ADC PARKS & GREENSPACE ARBORICULTURE

PLANNING APPLICATION: AW/355/14/T

ADDRESS: 4 The Drive Aldwick PO21 4DU

BRIEF DESCRIPTION: Fell 1 No Red Maple tree

← T 2 = RED MAPLE

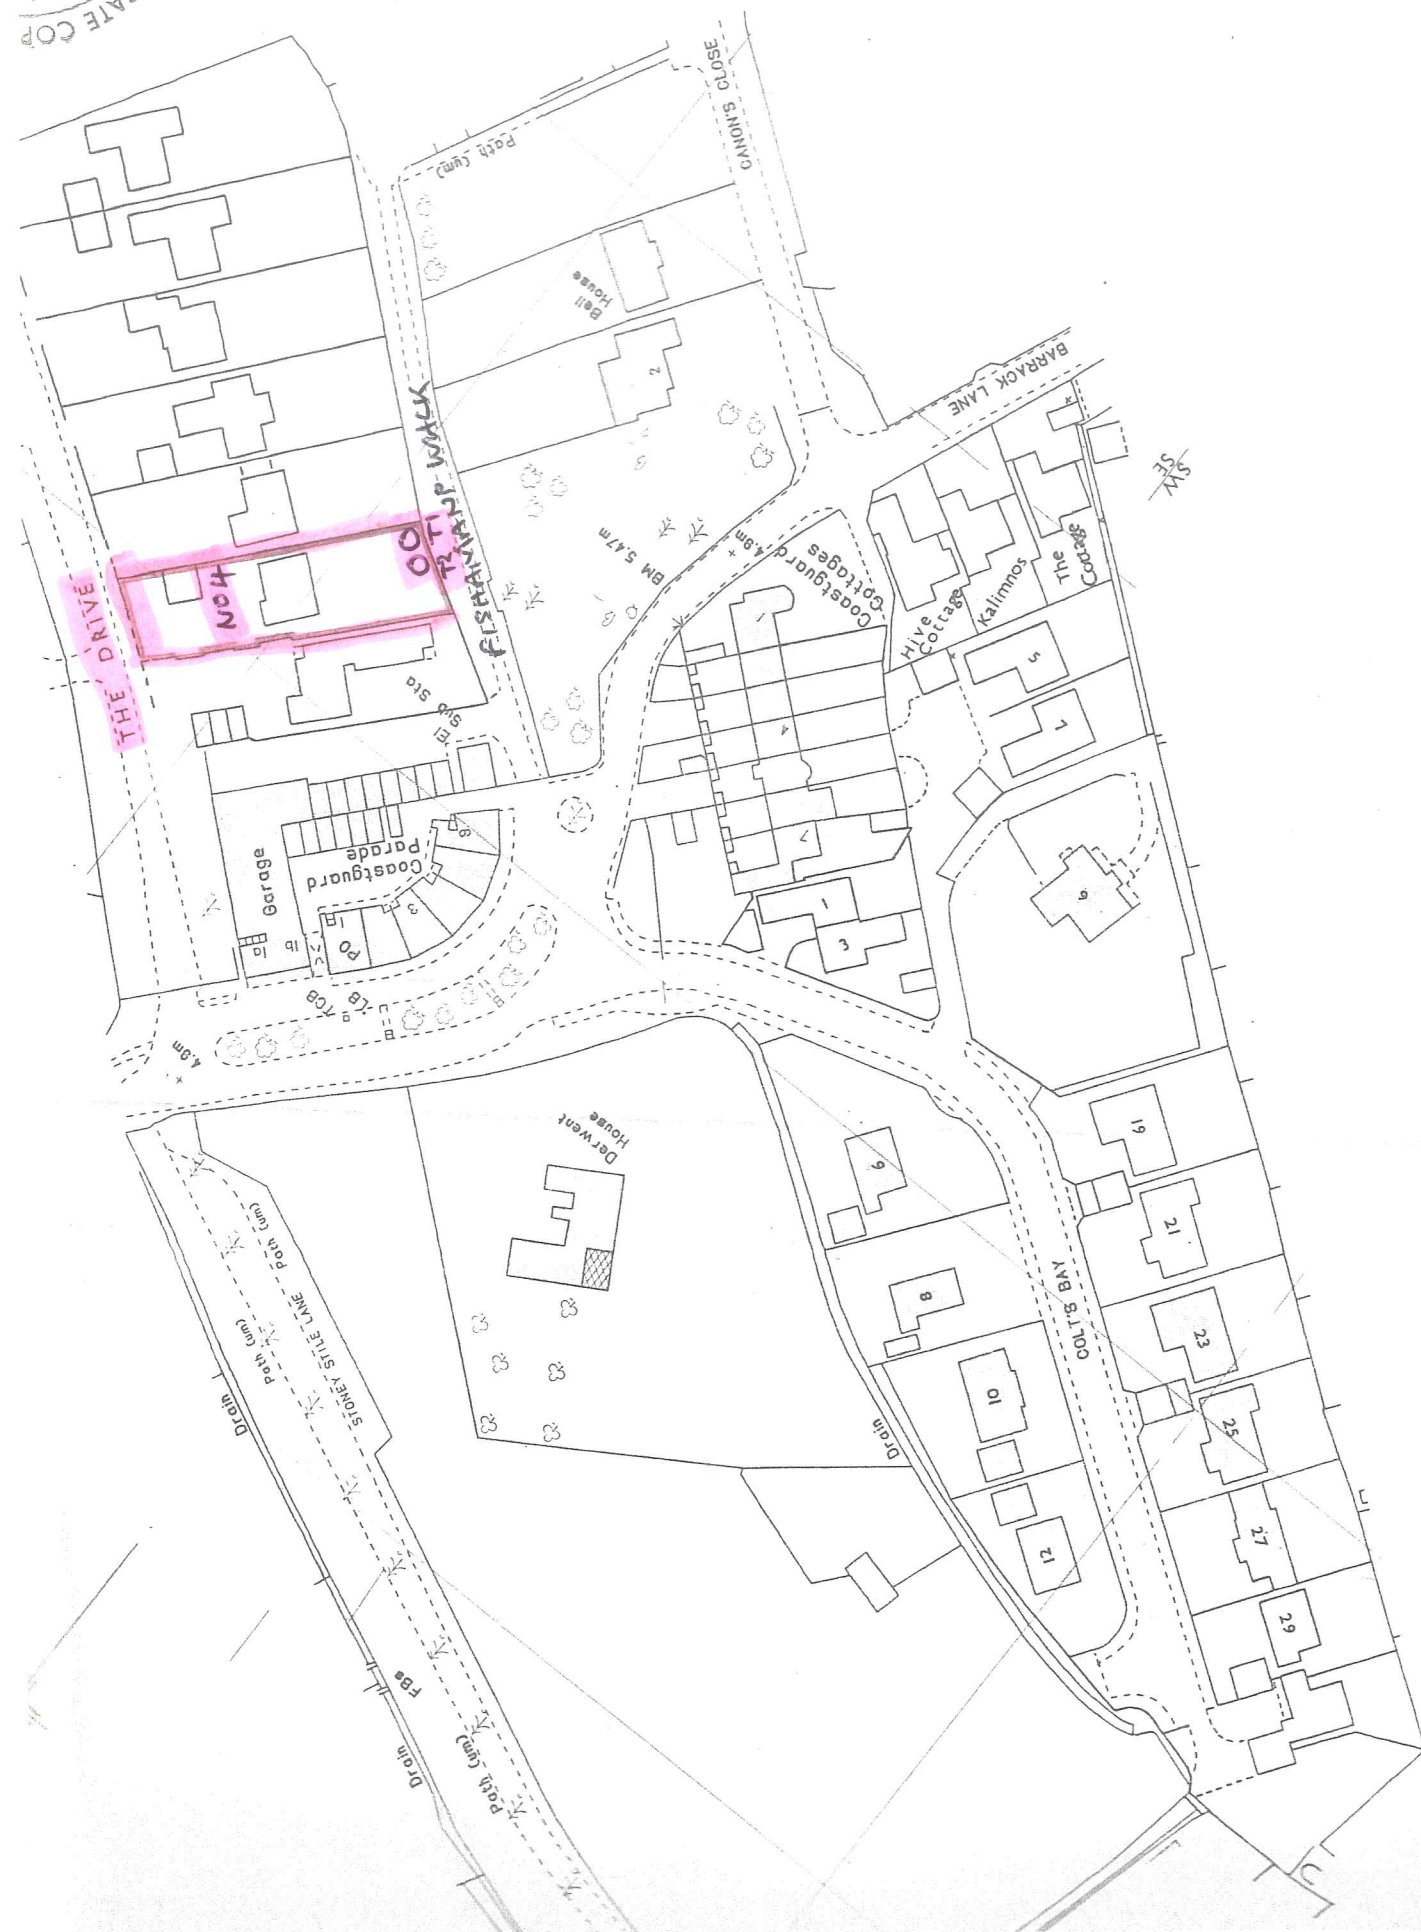
**T2 Species:** Red maple *Acer rubrum* **Height:** 8 meters **Average Branch Spread:** 1.5 meters **Crown Condition:** poor **Form:** poor **Age Class:** semi mature **Height to First branch:** 5 meters **Height and type of main unions:** trifurcates at 5 meters

- **T2** lies in Aldwick Bay conservation area, which is a high amenity landscape with young, semi mature, mature, and over mature trees specimens present. **T1** has no active TPO order.
- **T2** is located abutting the rear boundary of 4 the Drive, in the eastern area, west of **T1**.
- It was clear from the site inspection that **T2** is in a very poor condition, and has very poor crown density. Also there is clear evidence of poor pruning techniques (as there is a number of 'pegs' present).
- Speaking to the applicant/owner of **T2**, it was alleged that this individual did not flush last year. This would suggest this tree is standing dead.
- Given the overall condition of **T2**, the retention span of the outlined tree is likely to be greatly reduced.

- For the above reasons, **this tree would not be suitable for a TPO order.**
- I therefore would **have no objection to the proposed operation of felling of T2.**
